Response to Planning application from Hertfordshire County Council (T and CP GDP Order 2015)

District ref: 6/2023/1099/PN15
HCC ref: WH/16930/2023
HCC received: 26 May 2023
Area manager: Manjinder Sehmi
Case officer: Gideon Gasinu

Hatfield Avenue Hatfield Business Park Hatfield AL10 9FY

Proposed telecommunications installation: Proposed 15.0m Phase 8 Monopole and associated ancillary works

Title: **211 VIS SPLAY PLAN**

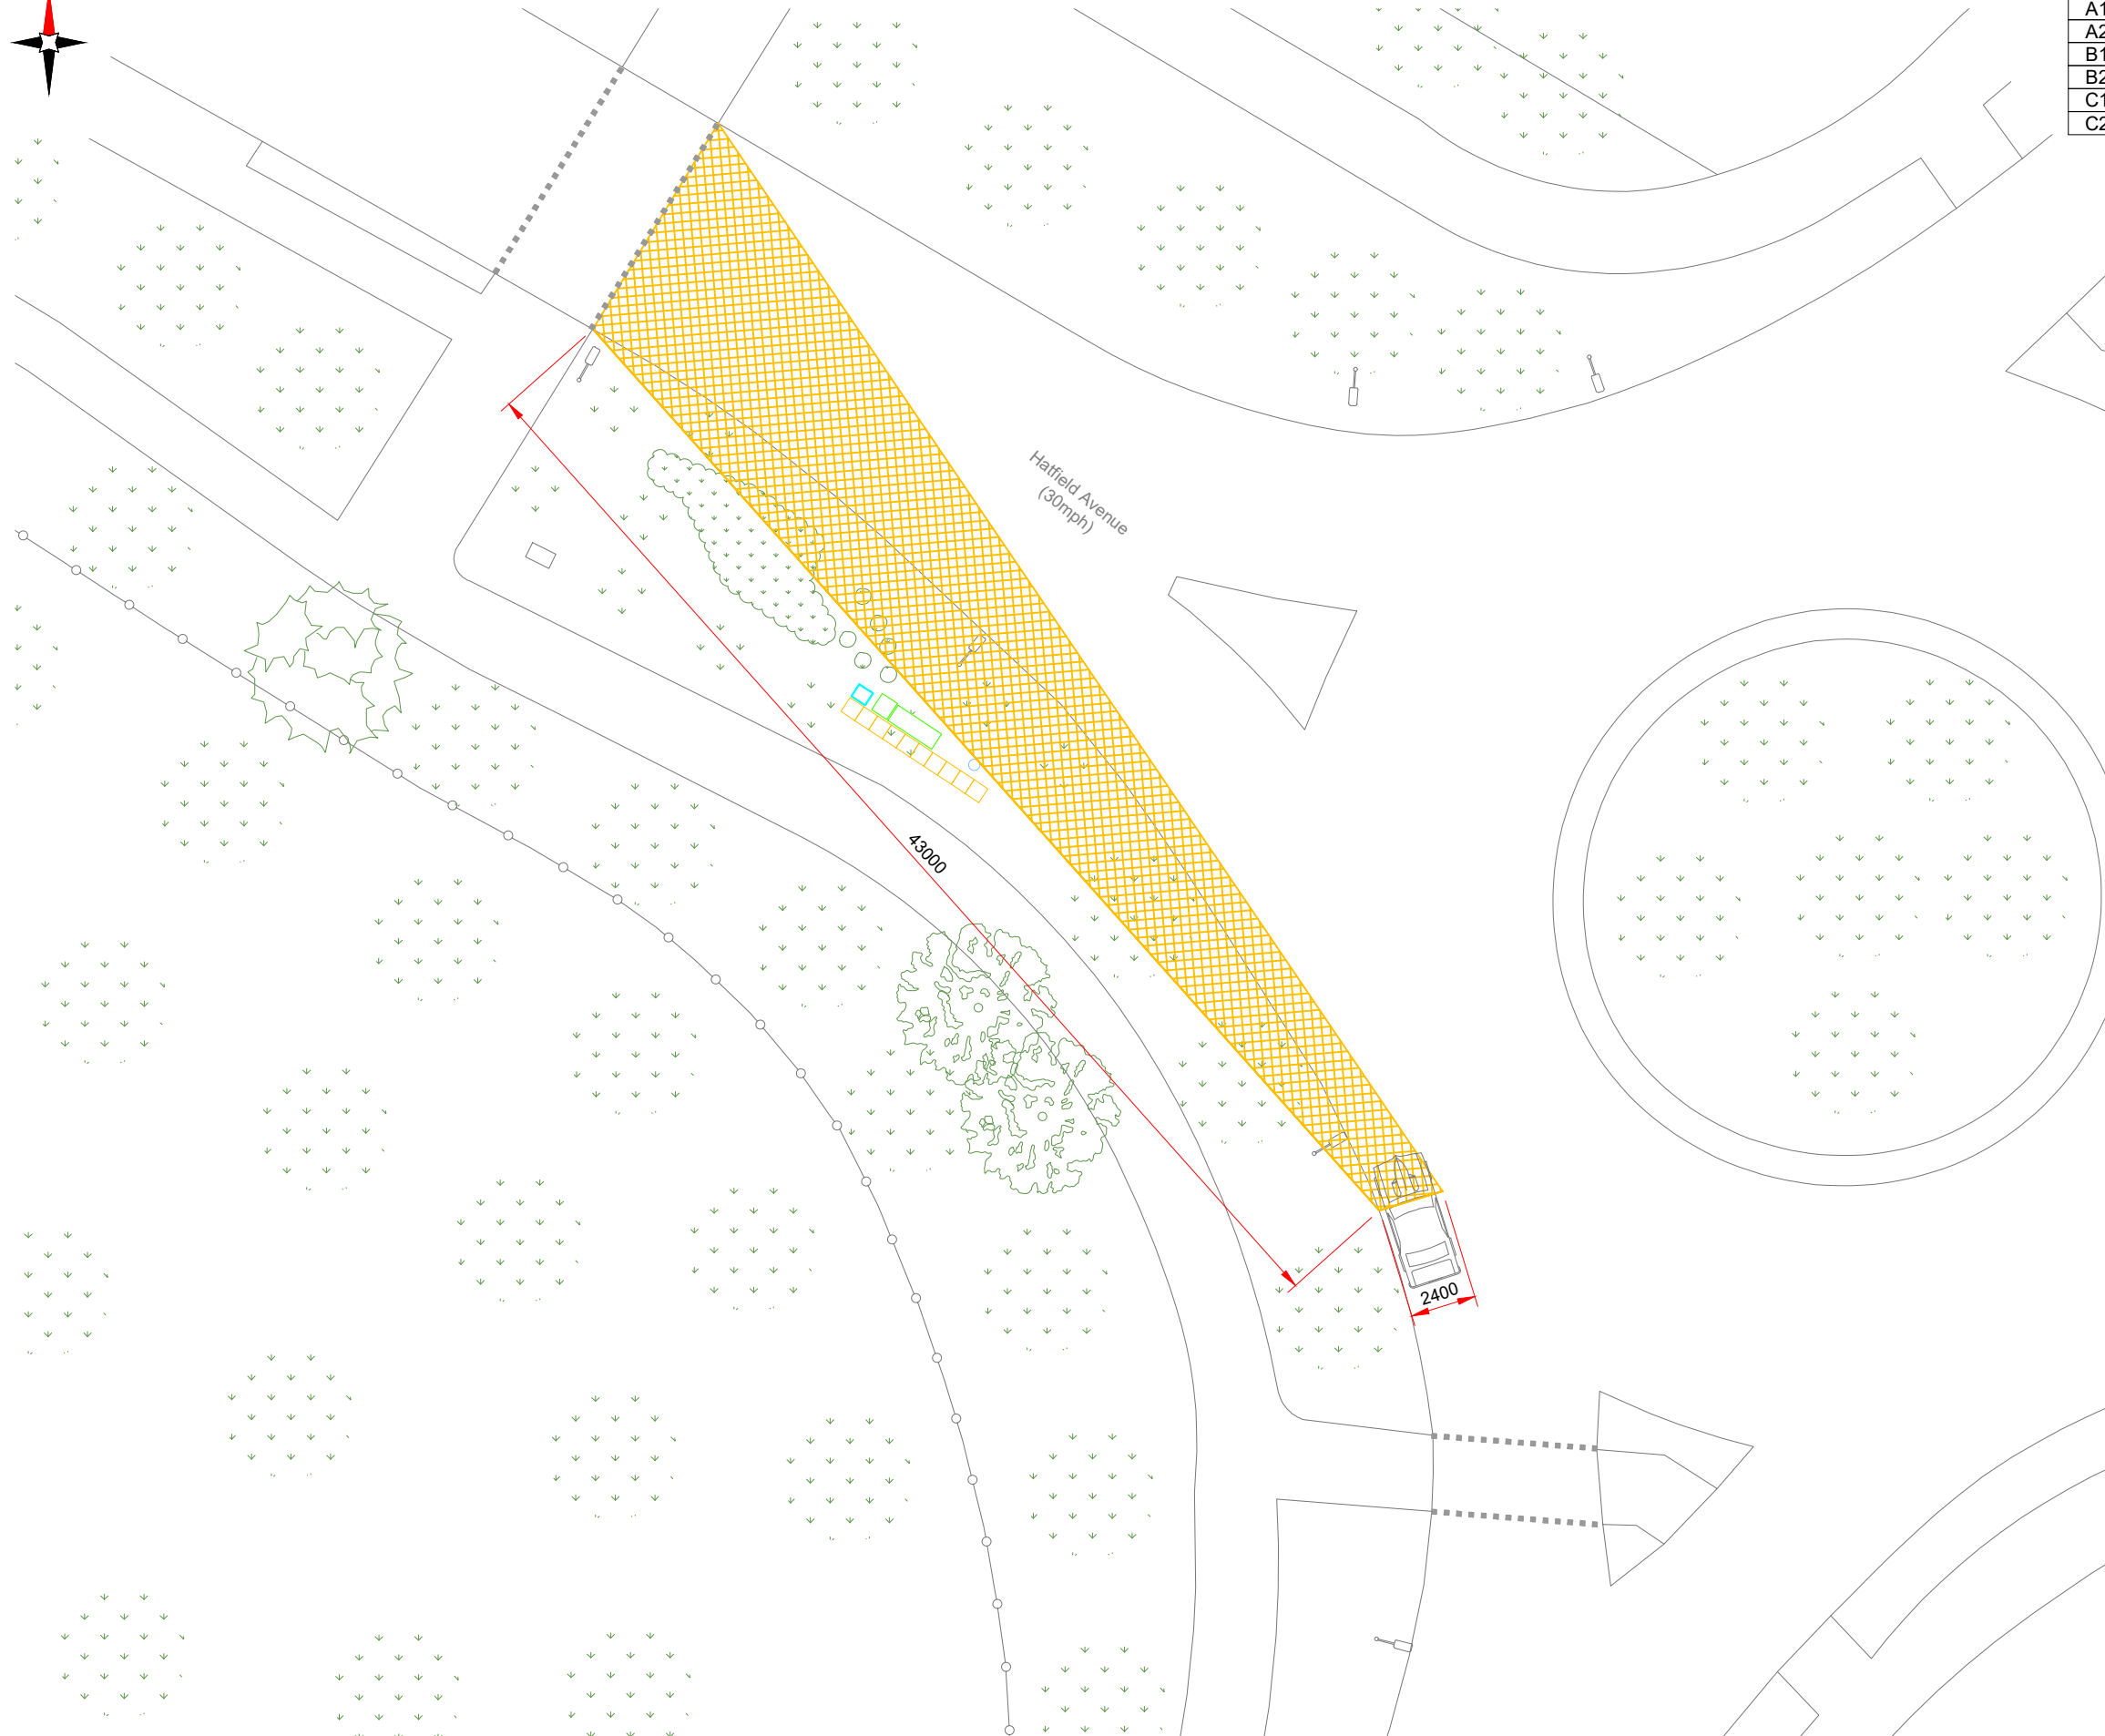
No plans showing pedestrian intervisibility splays have been shown. Given the location of the pedestrian crossing a condition has been included to provide a visibility drawing showing a pedestrian intervisibility zone from the southern arm (Gypsy Moth Avenue) in line with Figure 3.59 of DMRB CD 116

Title: **002 SITE LOCATION PLAN**

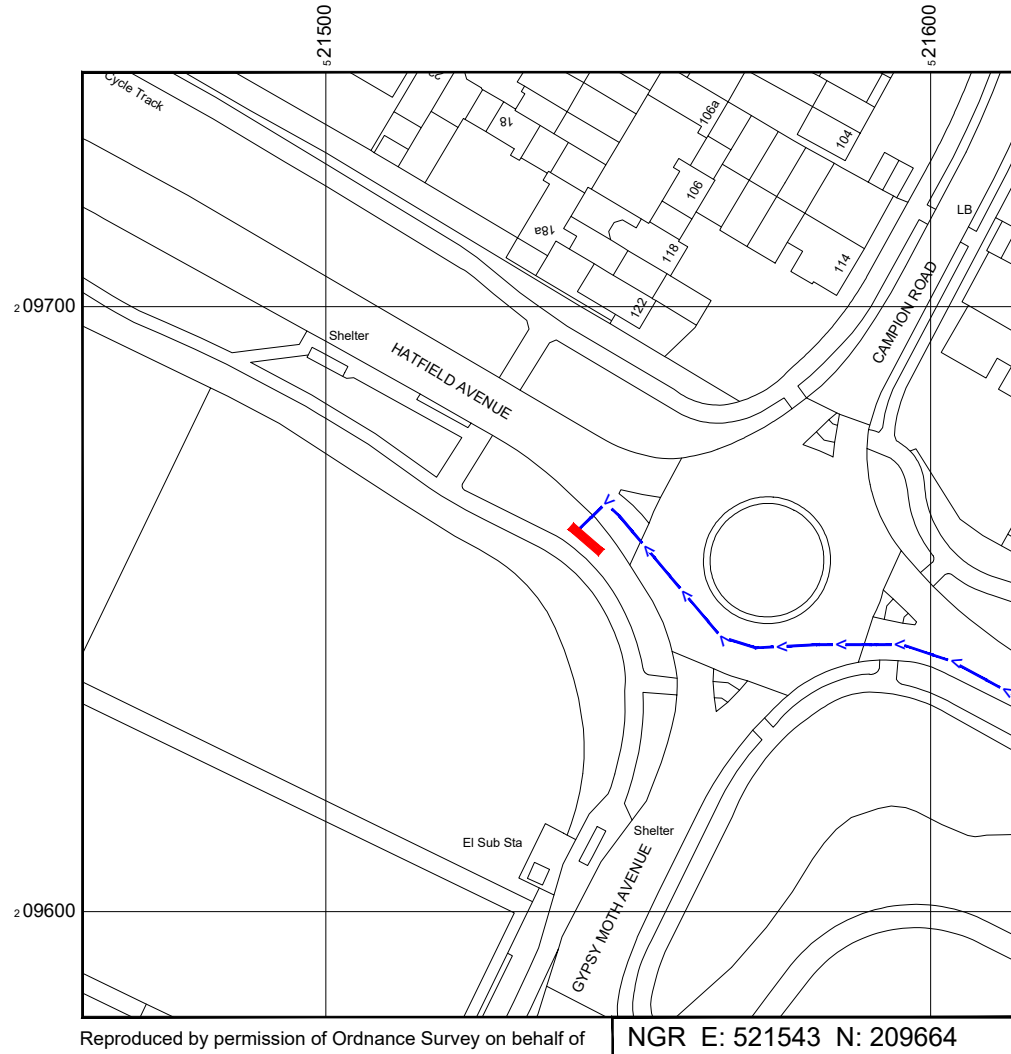
The proposals are for Telecommunications Determination: Installation of a 15.0m Phase 8 Monopole and associated ancillary works, on grass verge on at the corner of Hatfield Avenue/Gypsy Moth Avenue Roundabout.

The Highway Authority note the submission of materials in support of the planning application, including drawing numbers: WEH22203_M001 (site plan and elevation plan).

Title: **260 PROPOSED ELEVATION**

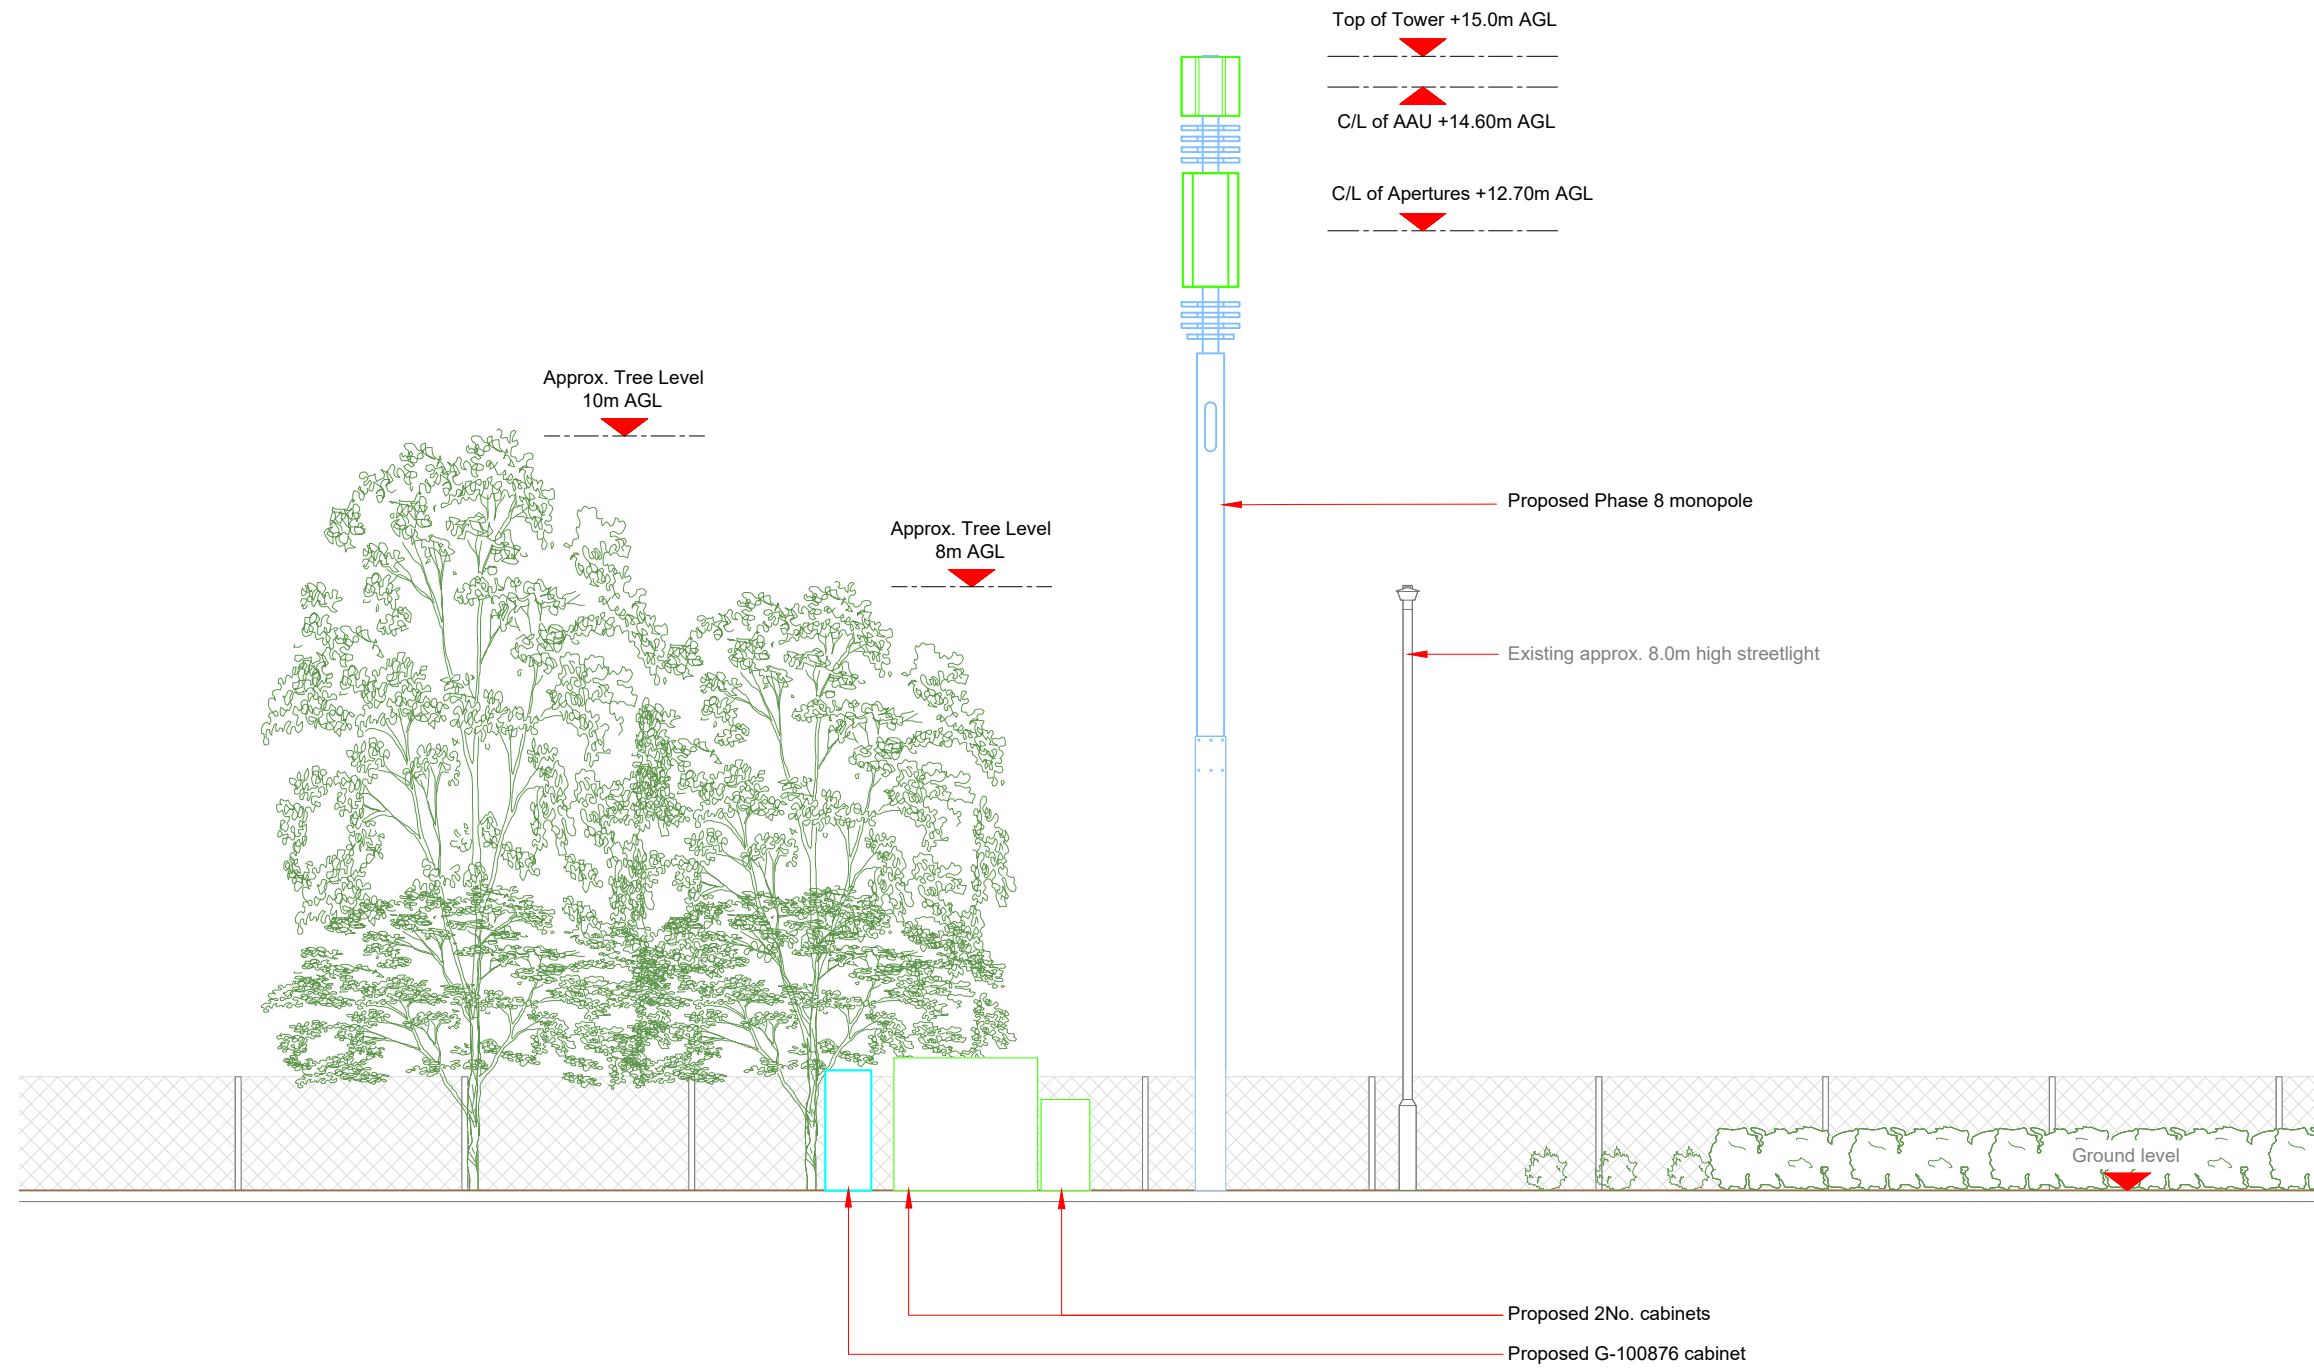
Reason for Refusal: No plans submitted to demonstrate the proposed location is outside the limits of visibility.
